DA Access Report

*Teloopa Estate – Stage 1A
Lot 5-7 of Masterplan,
Teloopa NSW 2026*

17 November 2022

Project: Telopea Estate – Stage 1A

DRAWING TITLE
BASEMENT 01 PLAN

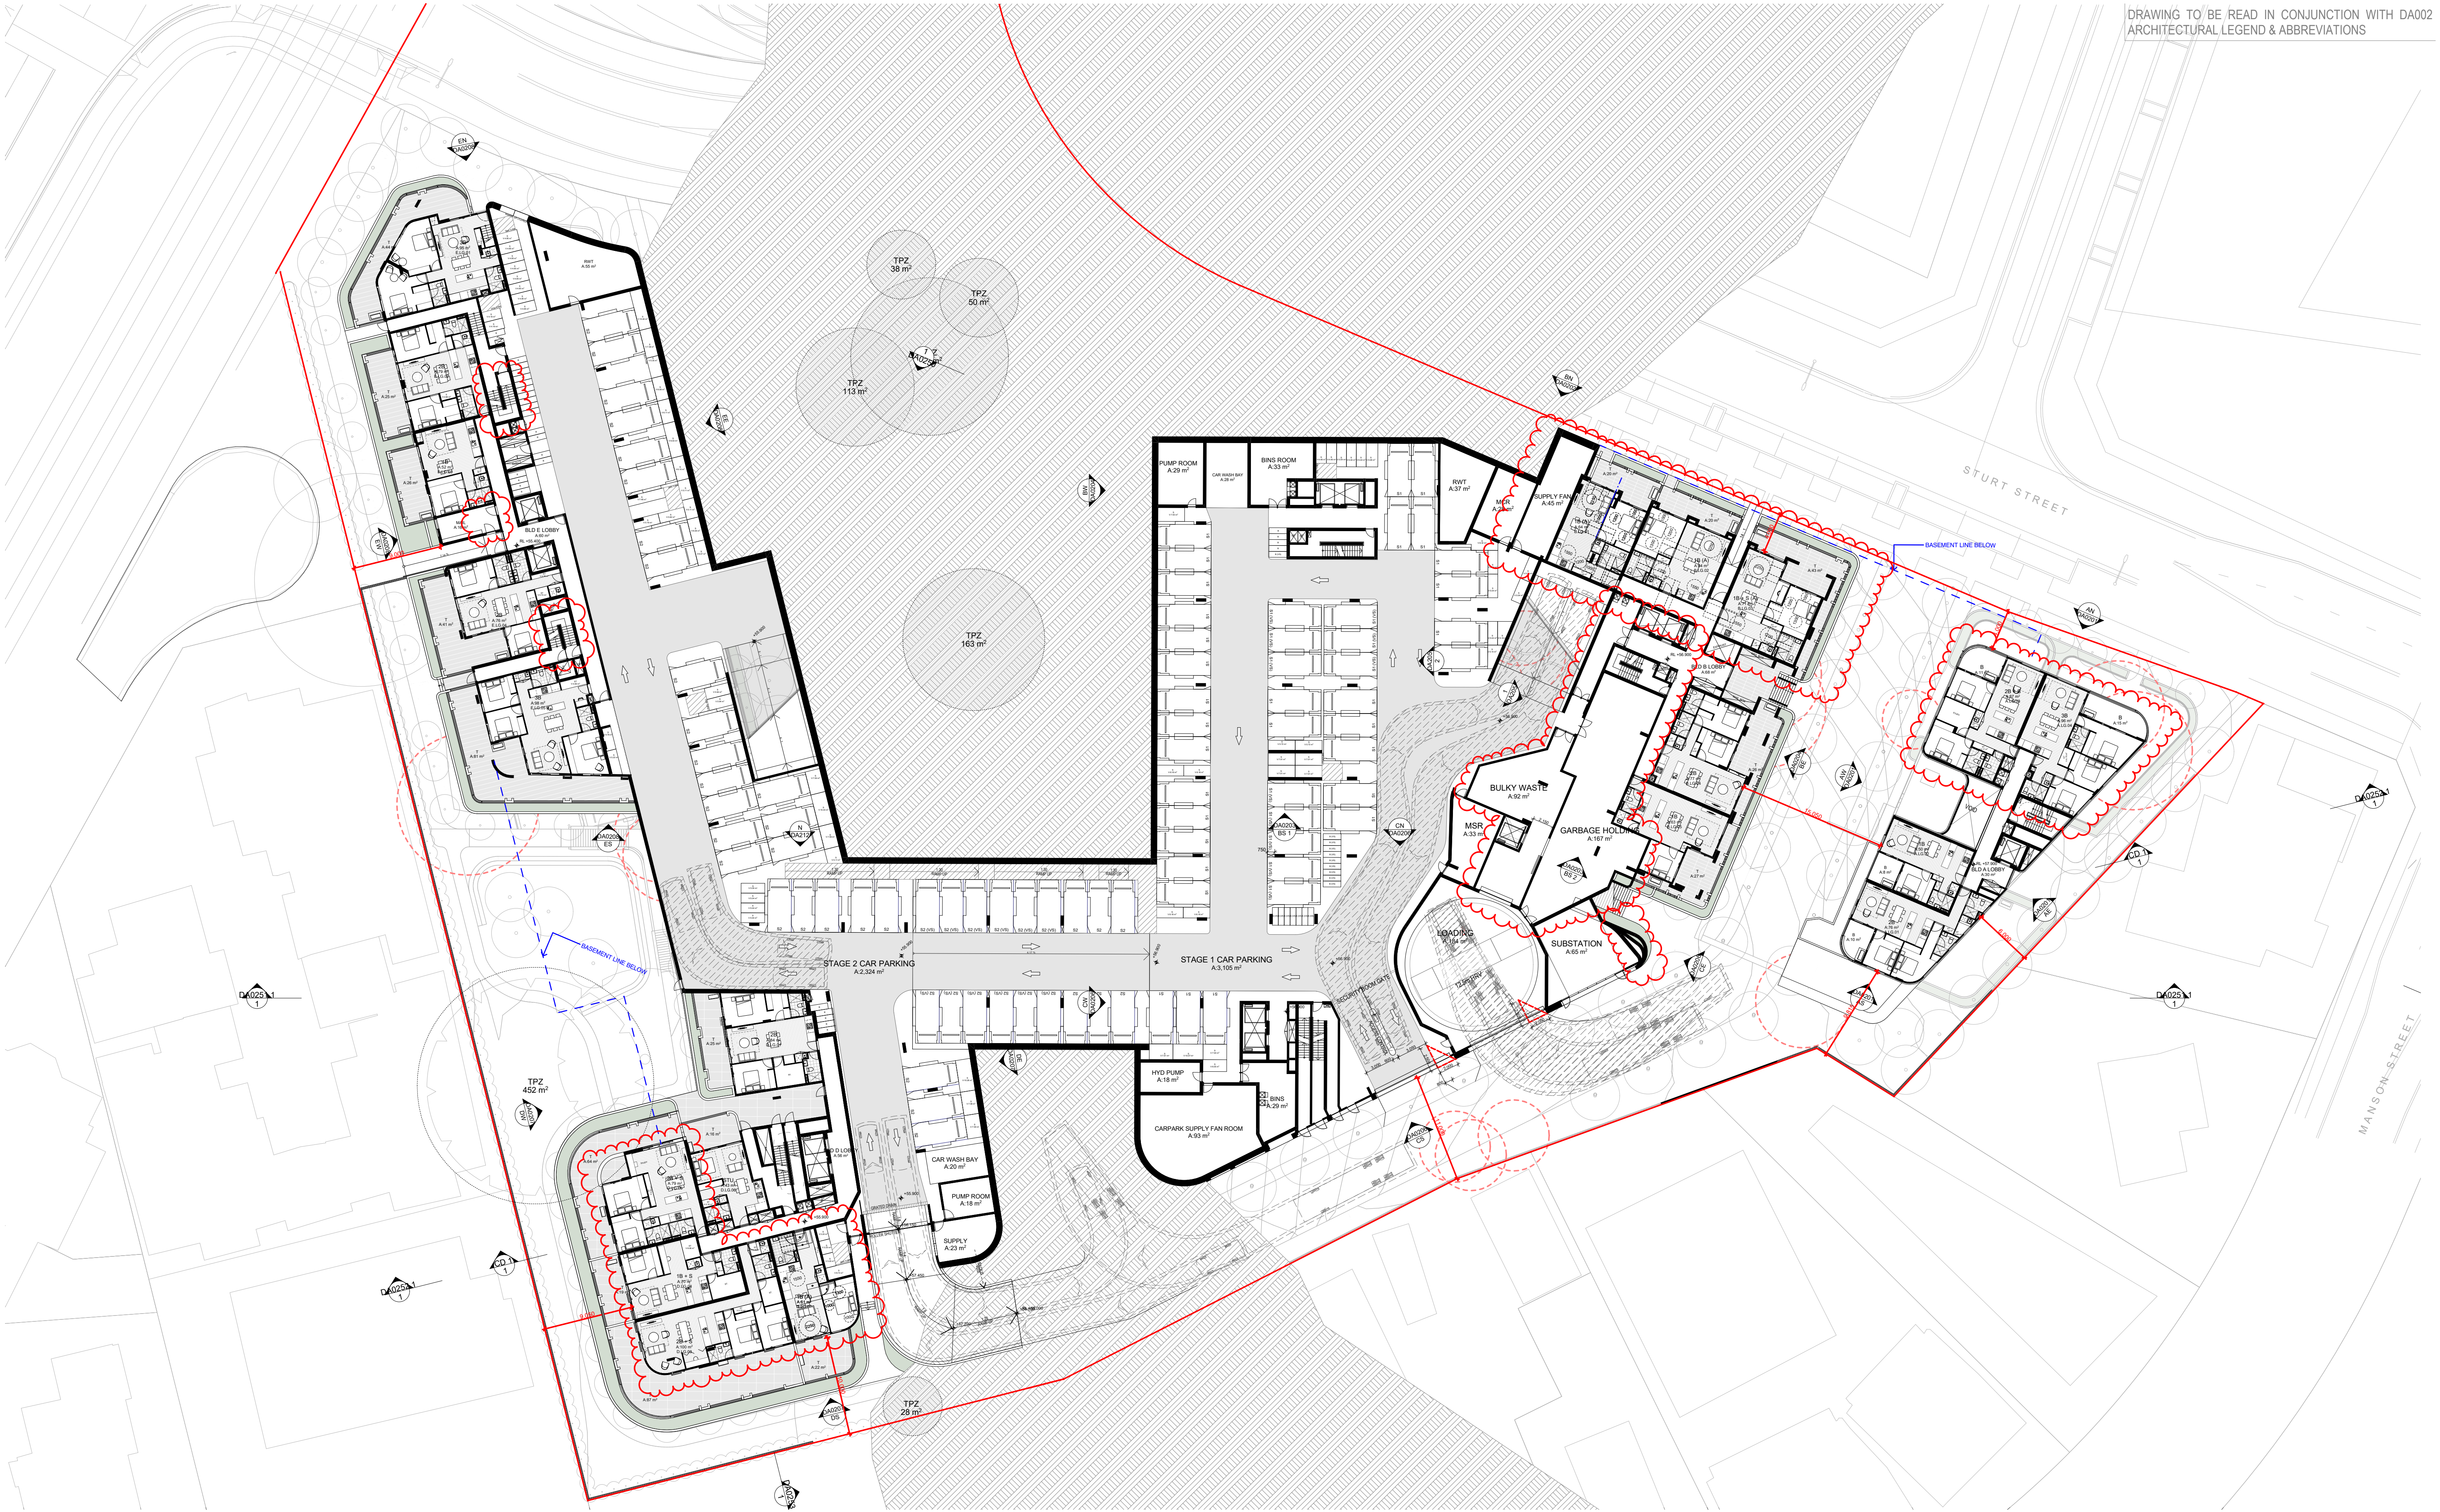
Within the residential building, there is suitable access within residential corridors to all sole-occupancy units located within the building. Corridors generally achieve minimum 1600mm clear widths with appropriate wheelchair turning areas located within the ends of corridors. Review is required of the end of corridor clearance in Building A, on Basement 01 which has 1200mm clearance.

DRAWING TITLE
UPPER GROUND FLOOR
PLAN

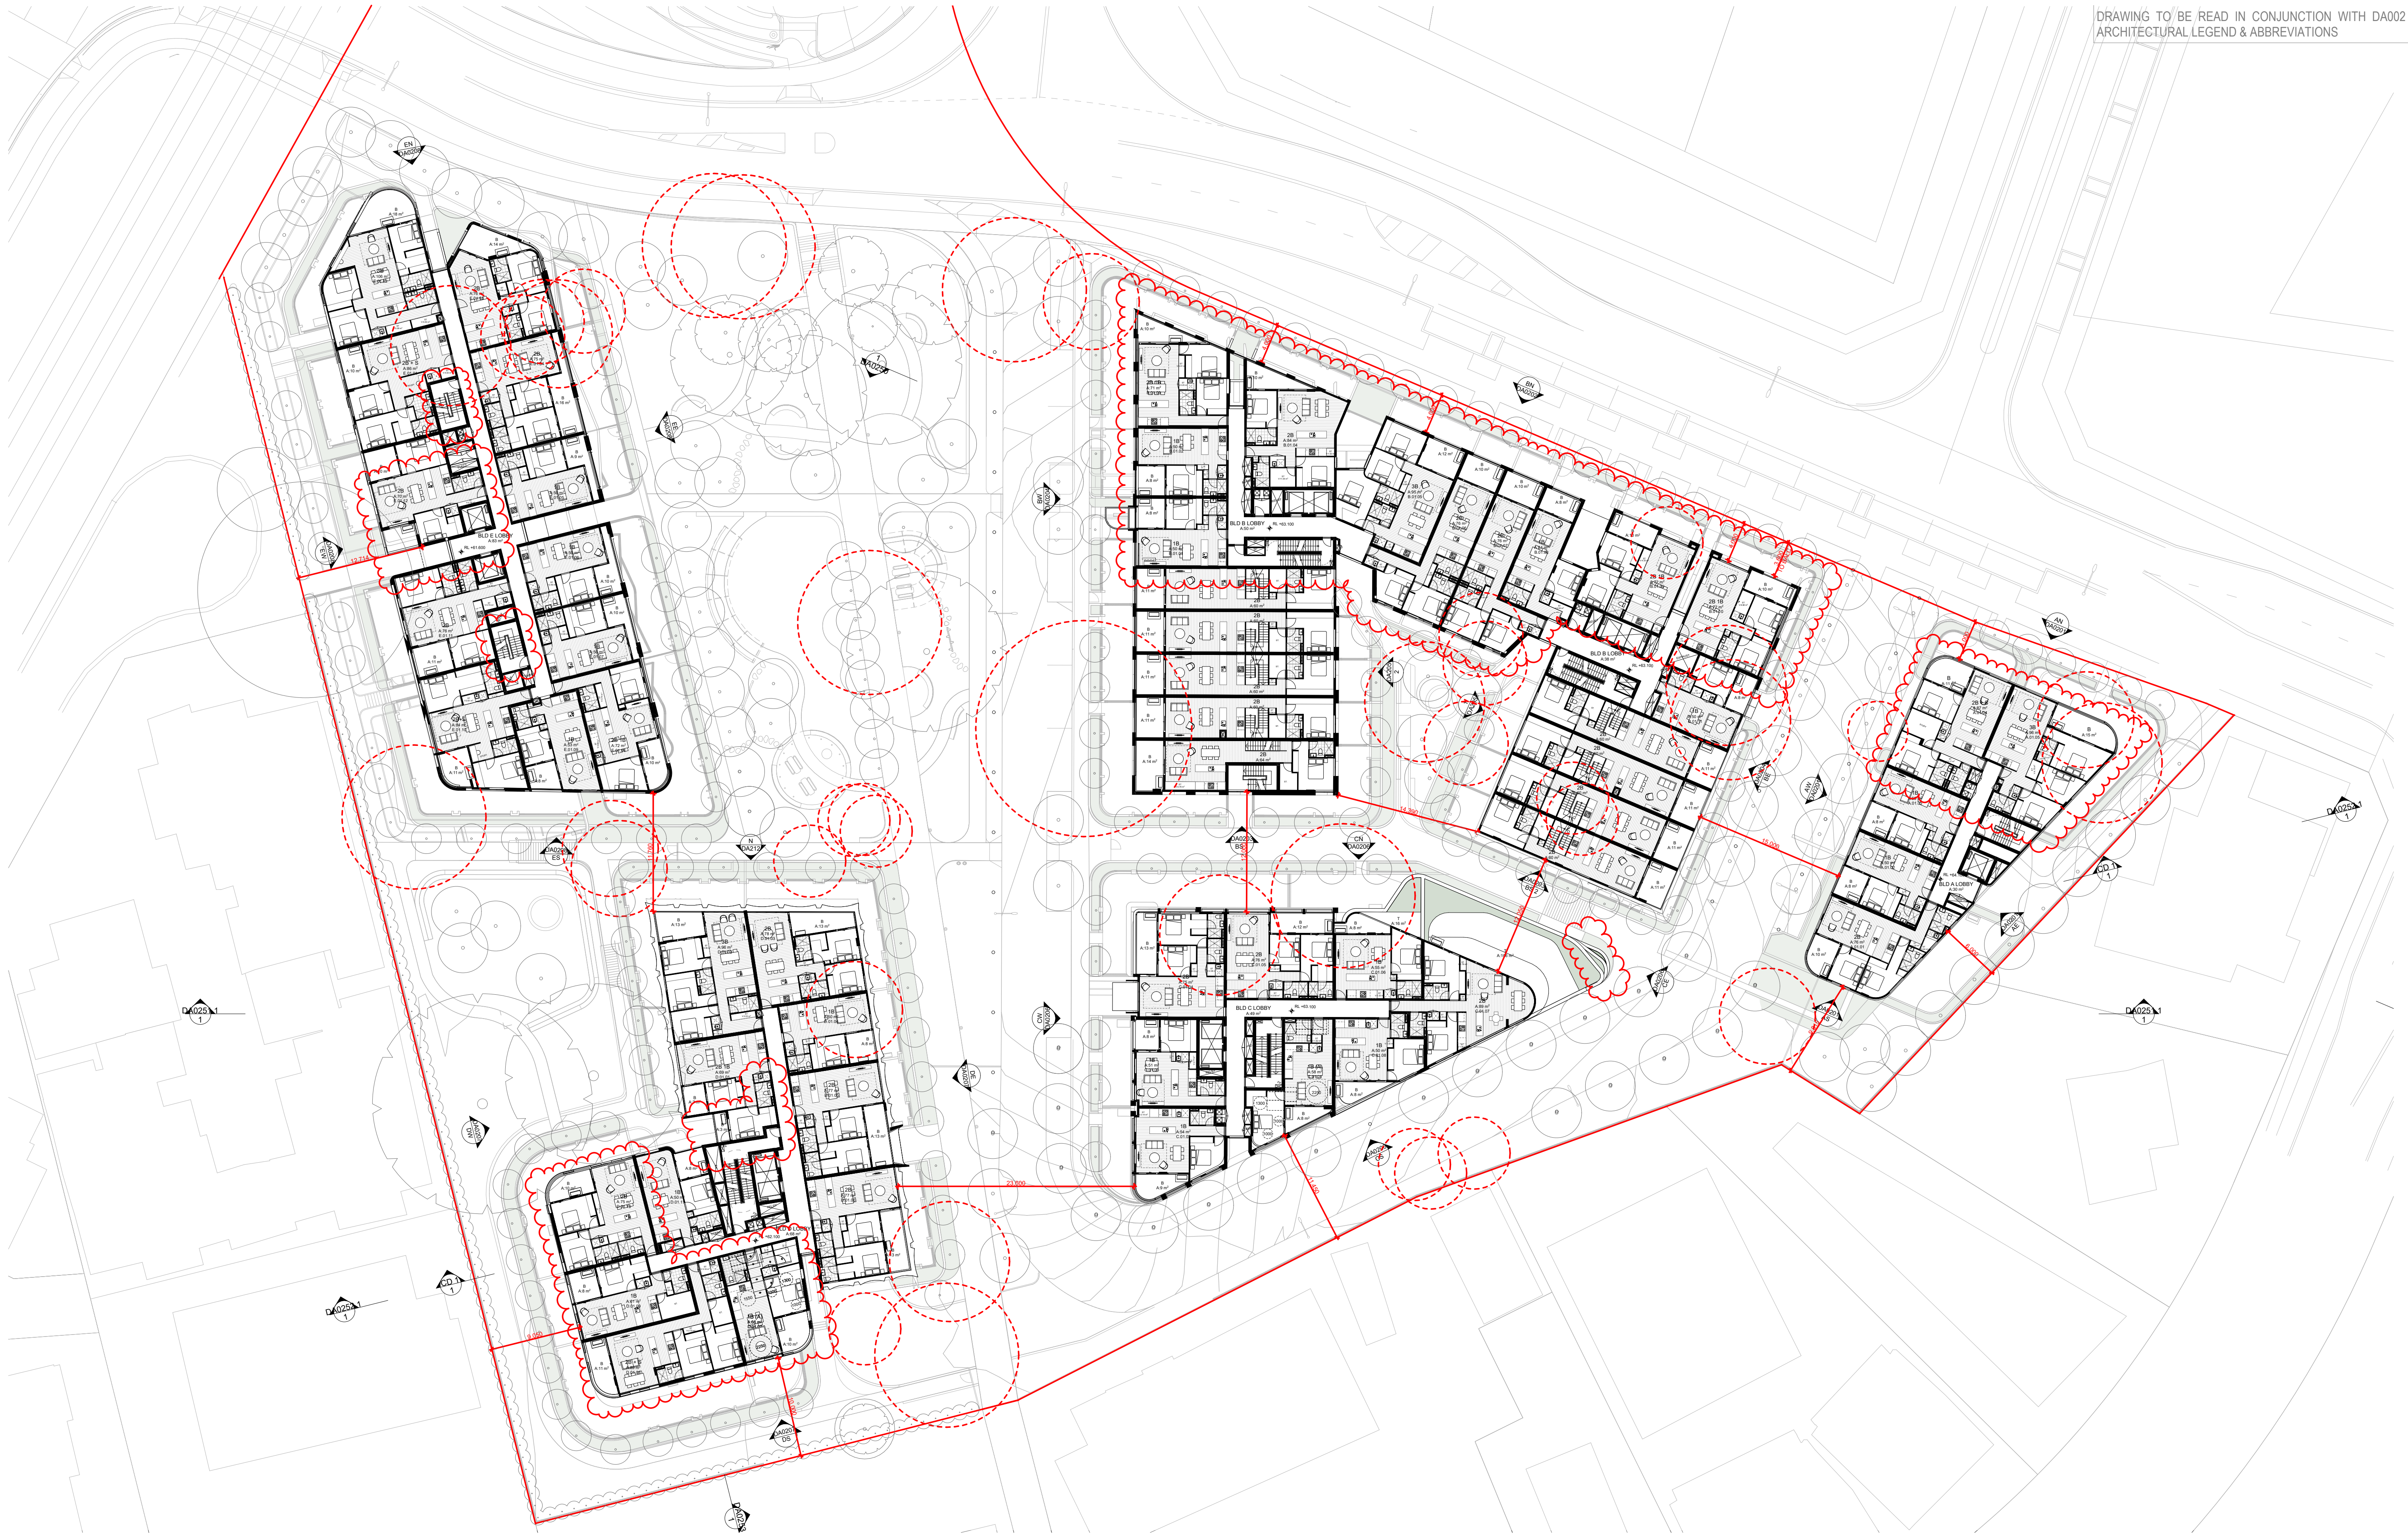
There is a 1:14 grade ramp and stairway from the central park located on the Upper Ground floor. The ramp is to be recessed from the building boundary to allow for appropriate handrail extensions and TGSIs clear of the traverse path of travel alongside the park and the entry door. The Building B lobby door is to be recessed further into the building to ensure appropriate clearances to the sliding automatic doors to the building lobby.

The buildings are connected through the central park area and additional communal outdoor spaces. The Central Park is located on the Upper Ground floor and is accessed via the stairway between Building D and E, and a second stair between Building B and C. There is currently no accessible path of travel. Alternatively, the internal street is to be gated with appropriate signage for residents and their guests with disability.
